**KELLER SPRINGS LOFTS**  
LOFT APARTMENTS IN ADDISON, TEXAS

**RFI**

RFI #: 39  
Date: 1/28/2012  
Job: EB-02 Keller Springs Lofts  
Phone: 877-777-5115

CC: David Gallagher (Embrey Builders LLC)  
Subject: Elevation conflict A1 part 5

SHEET NUMBER
3.1C
BLDG PLAN 'C'

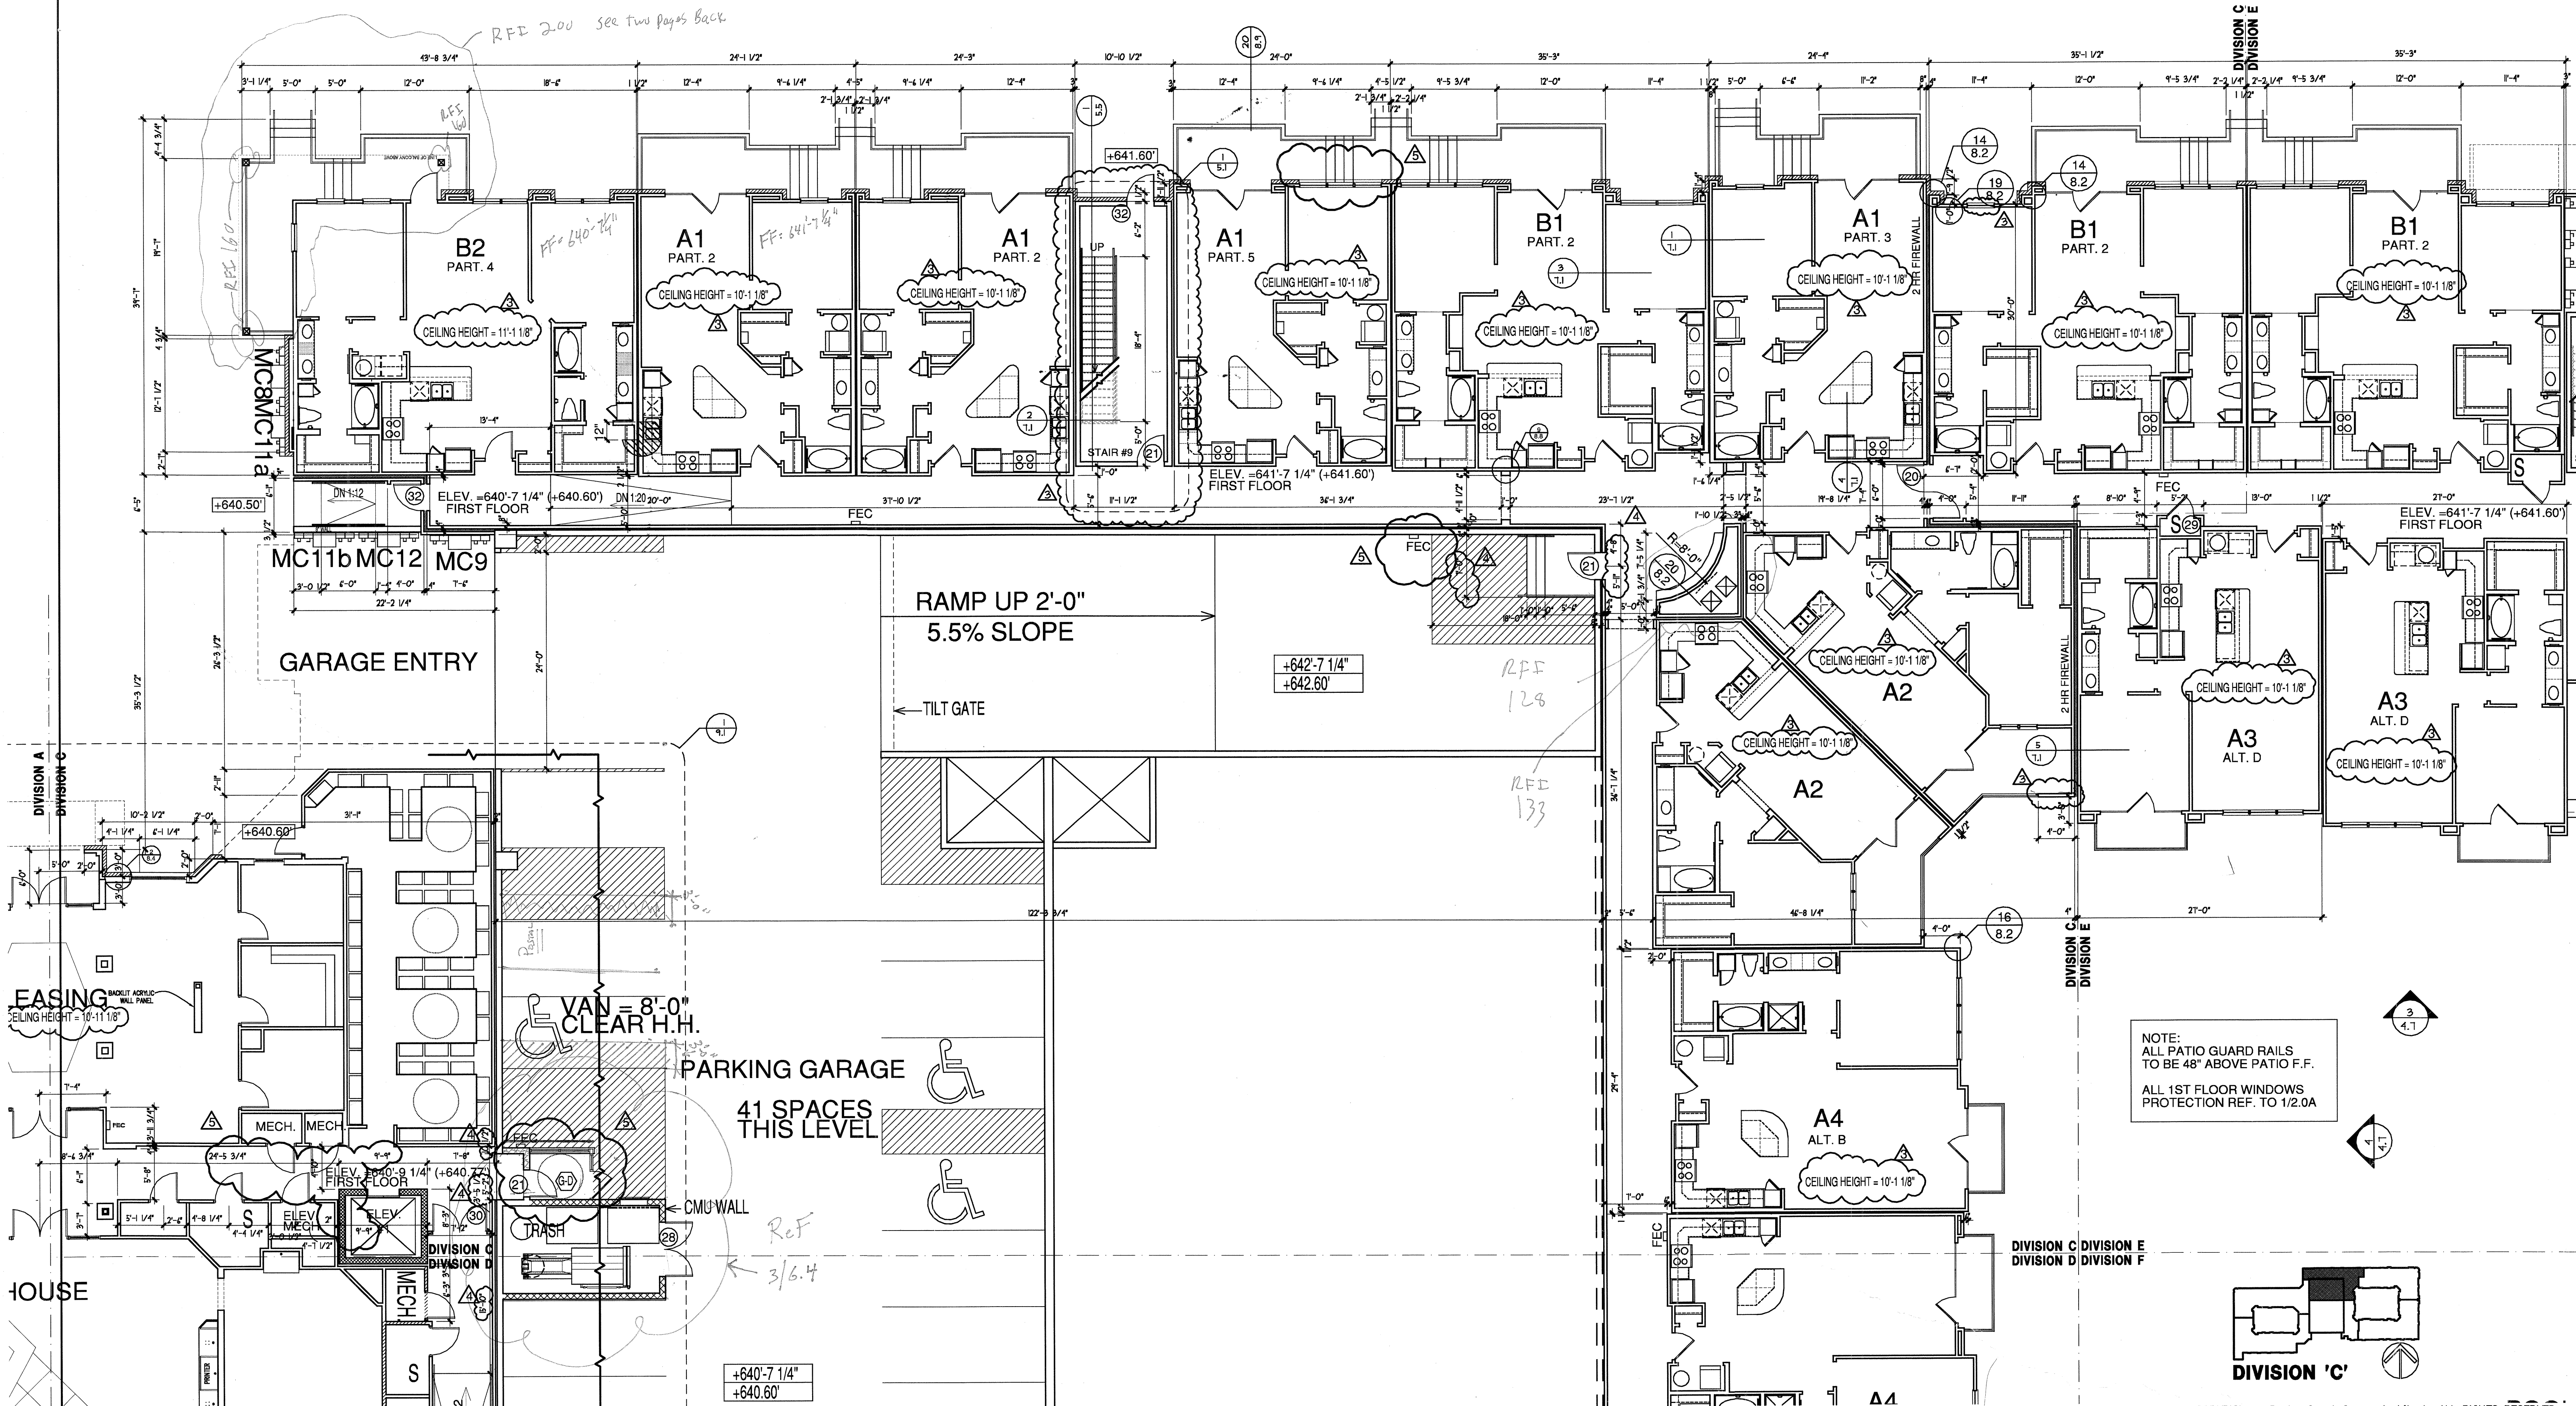
**Request:**  
Erik there is a conflict on A1 part 5 (1st floor) and A2 part 6 (2-4 floors). 2/4.4 shows these units to the left of stair tower #9 elevation clearly shows these windows matching the B3 mark windows of the adjoining B1 units. However, 12/2.2 and 13/2.2 calls out mark 17 which is 3x6' 8" triple fixed french doors. Please see attachments.

**Response:**  
The elevation is drawn accurately per the design intent.  
The plans have been updated.  
see next page.
